From: John Kelly 
Sent: 28 August 2018 07:14
To: Simon Davis
Cc: Neil Crowther
Subject: Attn:- Mr S Davis and N. Crowther PLANNING REFERENCE: FP/171/18/PL

2 WELLERS CLOSE – FELPHAM – BOGNOR REGIS – PO228FS

PLANNING REFERENCE: FP/171/18/PL

I hereby submit my objections without prejudice, as to why the above mentioned application, submitted by Worthing Homes for 18 affordable homes, should not be approved.

SITE LAYOUT

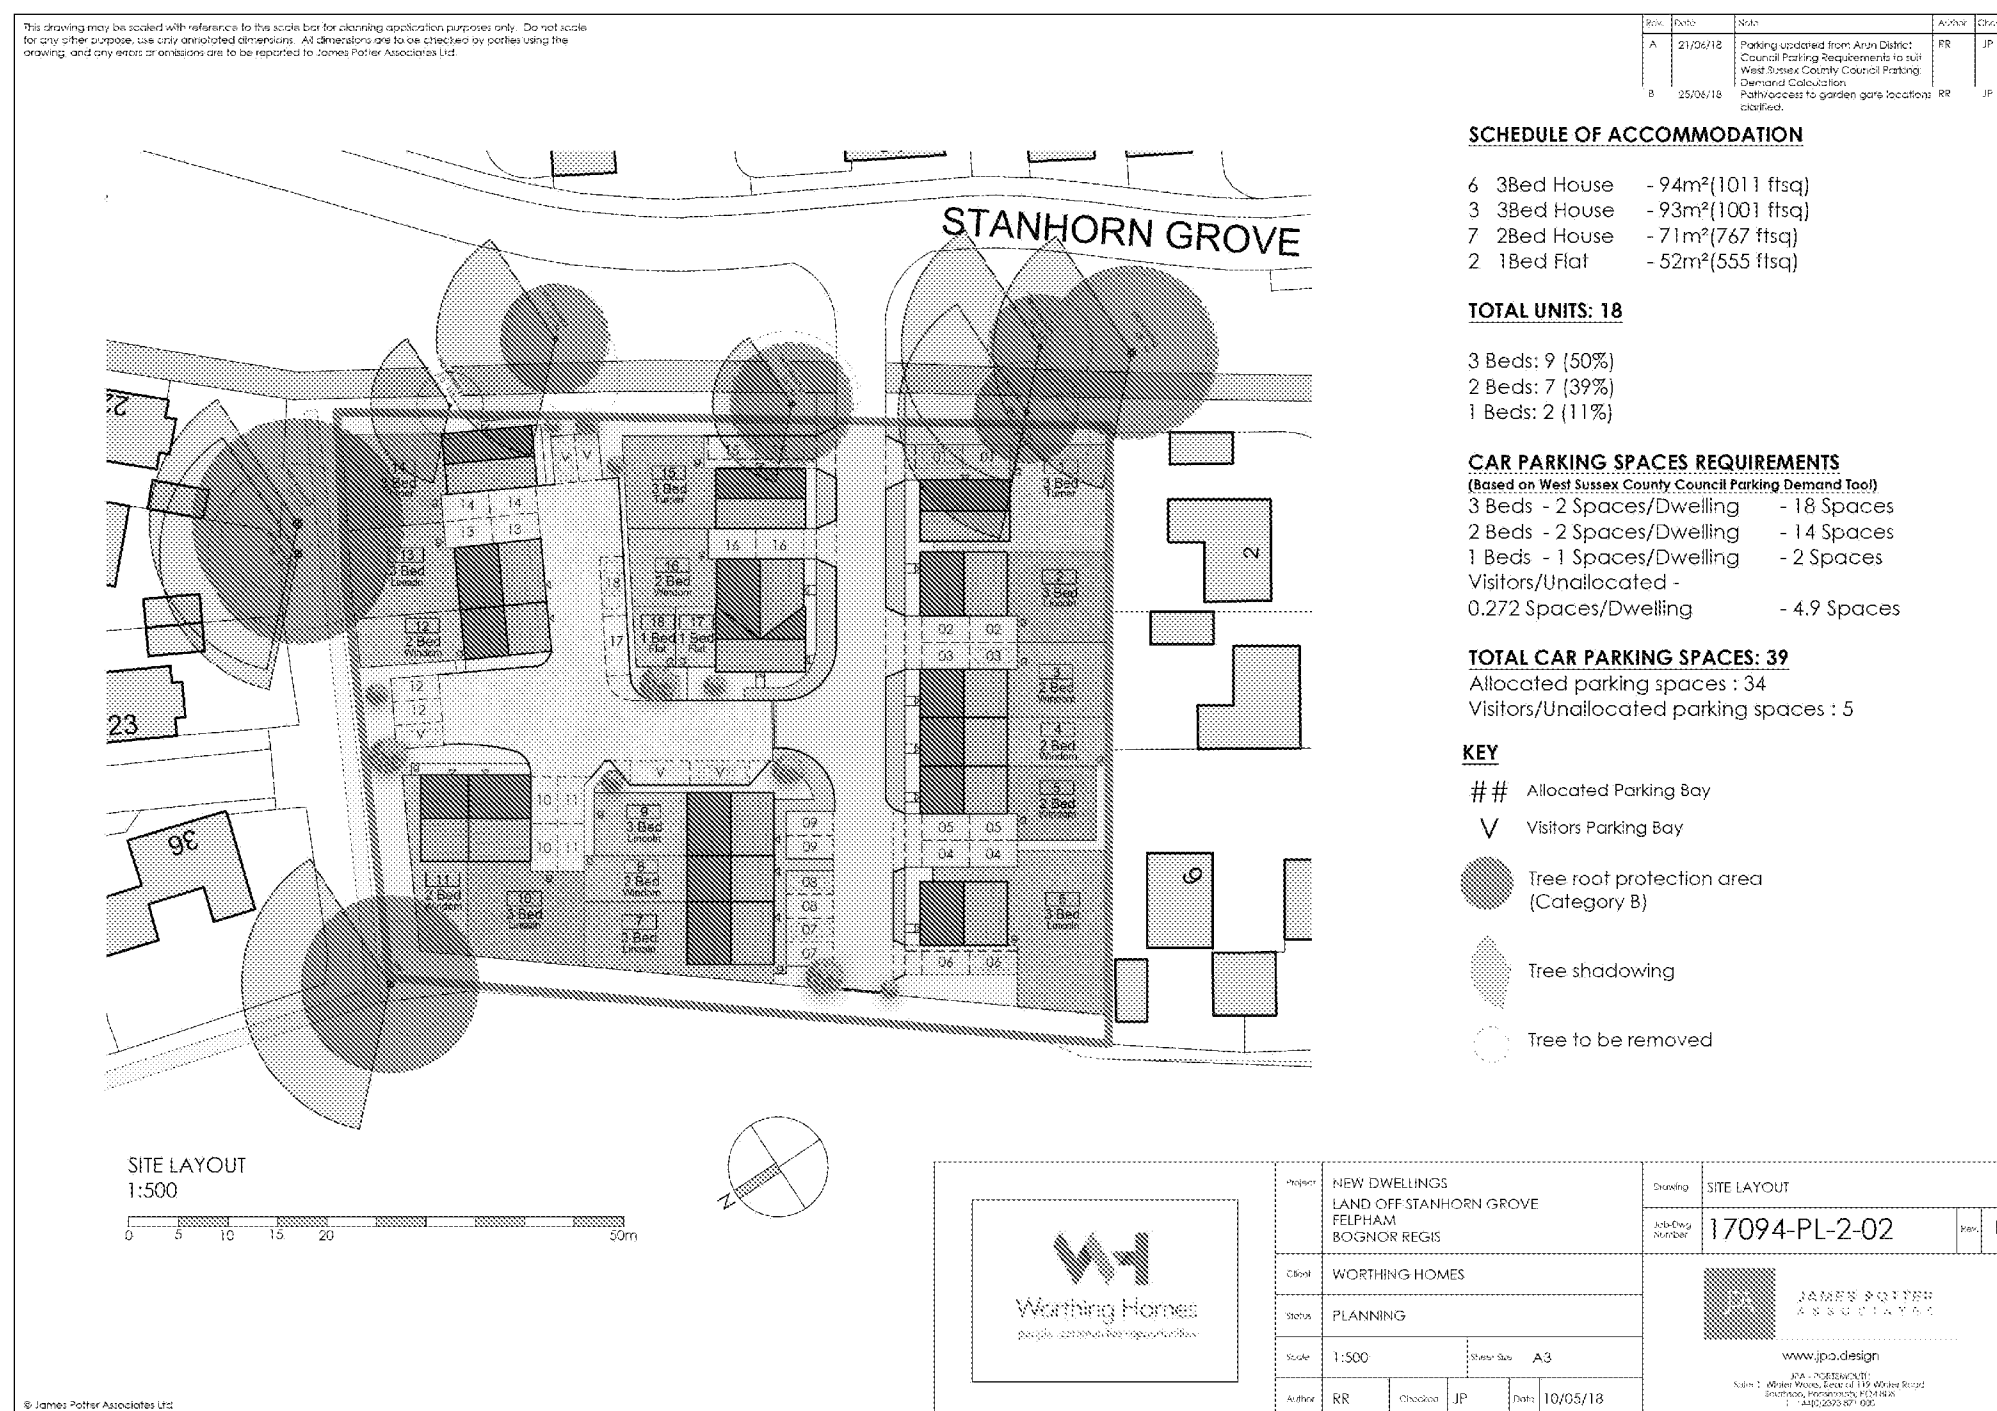
On the plan 17094-PL-2-02 Rev B, it shows dividing fences of the proposed new homes, numbers 1-2-3-4-6, adjoining the boundary fences of homes in Wellers Close, numbers 2-4-6. There cannot be any mechanical fixings made to the existing fences and an access path should be considered, as it shows for property 5. It would benefit future access to all, should it be needed.
